The Secretary  
NSW Department of Planning, Industry and Environment

6 May 2021

I refer to the Department's below email of 4 May 2021 regarding the notice of exhibition of the Environmental Impact Statement (EIS) for State Significant Development SSD-8845345 Budawang School for Specific Purposes for 'Construction and operation of the Budawang School for Specific Purposes' at 17 Croobyar Road, Milton (Lot 200 DP 1192140) in the Shoalhaven City Council Local Government Area (LGA). Submissions need to be made to the Department by 2 June 2021.

1 SITE PLAN  
1 : 250

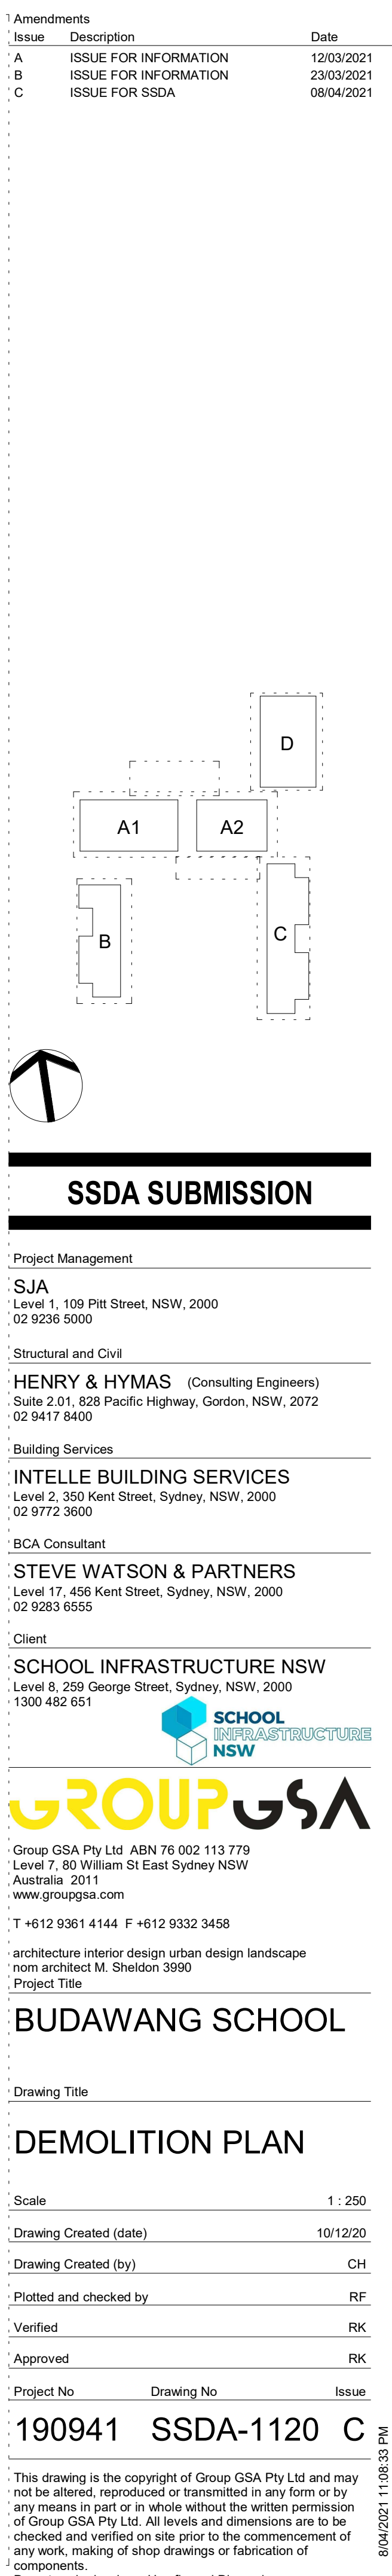
The proposed padmount substation is shown in the following extract of the Site Plan from the Architectural Drawings.

From Endeavour Energy's perspective the fact that provision is being made for a padmount substation is a positive. Endeavour Energy's general requirements is for a padmount substation to be at ground level and have direct access from a public street (unless provided with appropriate easements for the associated underground cables and right of access).

- Easement with a minimum size of 2.75 x 5.5 metres (single transformer).
- Restriction for fire rating which usually extends 3 metres horizontally from the base of the substation footing / plinth and 6 metres vertically from the same point.
- Restriction for swimming pools which extends 5 metres from the easement.

- Personnel access doors and fire exit doors to a building are not permitted within the fire restriction area.
- Gas mains/pipes shall not pass through the fire restriction area.
- A 10 metre clearance distance shall be maintained between substation and fire hydrants, booster valves, and the like in accordance with AS2419.1 'Fire hydrant installations System design, installation and commissioning' as updated from time to time.
- Consideration should be provided to the appropriateness of the landscaping relative to the fire restriction for the substation. Any landscaping that potentially could transfer / provide connectivity for flame or radiant heat from a fire in the substation to a dwelling or building should be avoided.
- The storage of and / or use of flammable, combustible, corrosive or explosive material within the fire restriction should be avoided.

Generally it is the Level 3 Accredited Service Provider's (ASP) responsibility (engaged by the developer) to make sure that the substation location and design complies with Endeavour Energy's standards the suitability of access, safety clearances, fire ratings, flooding etc. As a condition of any Development Application consent the Department Council should request the submission of documentary evidence from Endeavour Energy confirming that satisfactory arrangements have been made for the connection of electricity and the design requirements for the substation, prior to the release of the Construction Certificate / commencement of works.
